From: Kathryn Welch
Sent: 14 April 2026 09:47
To: 'Jessica Fermor' [REDACTED]
Subject: RE: FW: Y/10/26/PL Rookery Farm
Importance: High

Subject: Y/10/26/PL Rookery Farm

As discussed, it appears that the proposal has evolved beyond the original intention of simply providing 1 new dwelling. Given the extent of development to the rear, the application should be amended to include the change of use of the agricultural land behind the barn to residential use. I would also suggest that the application does not need to refer to the demolition; instead, a retrospective application for the erection of the number of new dwellings would be more appropriate.

2601_200_PL0
*** PROPOSED DRAWINGS**

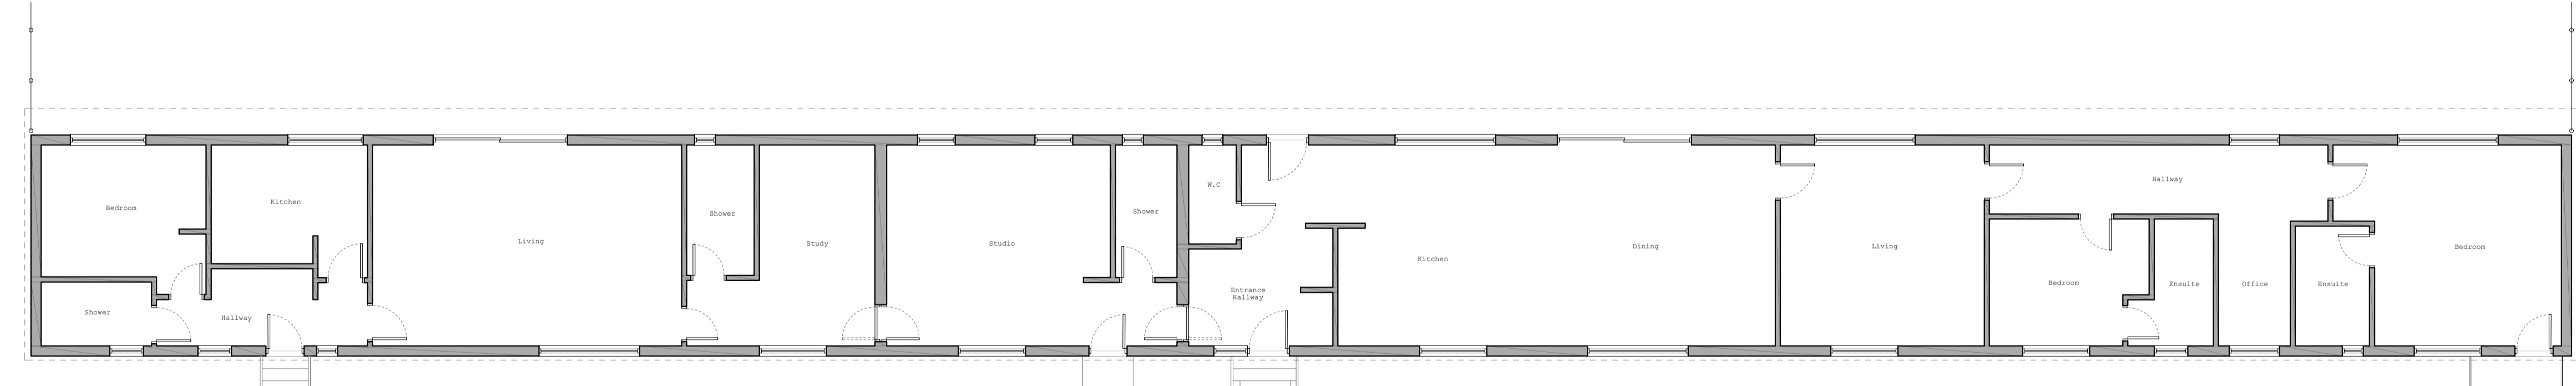
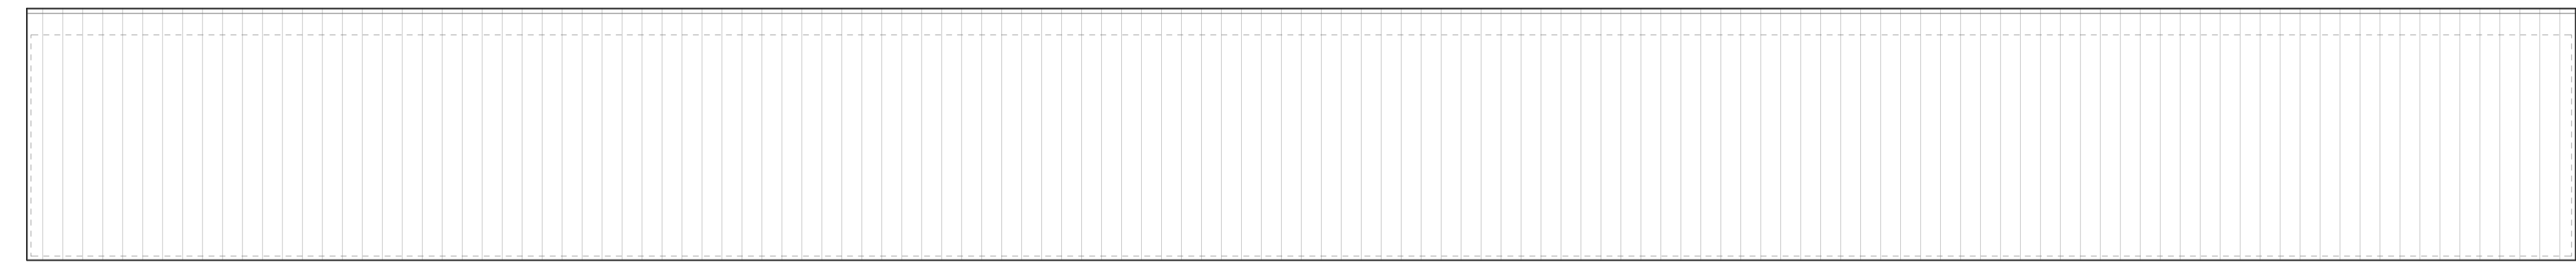
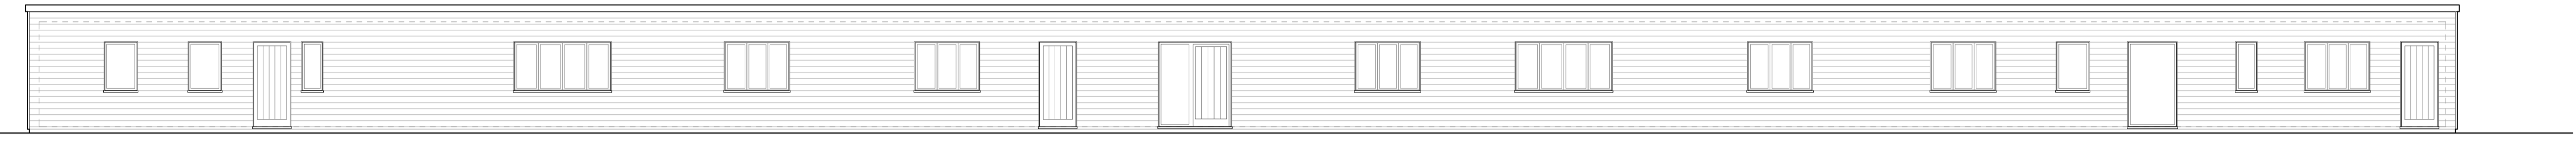
In addition, the plans do not clearly align with a layout comprising one dwelling and one annex. At present, the level of conflicting information renders the application incapable of being approved in its current form.

With regard to the number of dwellings on the site, I consider it evident that; despite the interconnectivity, the building has been designed to function as up to three separate dwellings. Evidence observed on site, including the number of front doors, subdivision of the land, and the number of ASHP units, has informed this view. I have also been provided with a Building Control report which confirms that the structure was designed as three separate dwellings for the purposes of fire-spread regulations.

Finally, I noted during my visit that construction of a pergola has commenced at the rear of the property. Given the scale of this structure, I would recommend including it within the submitted plans.
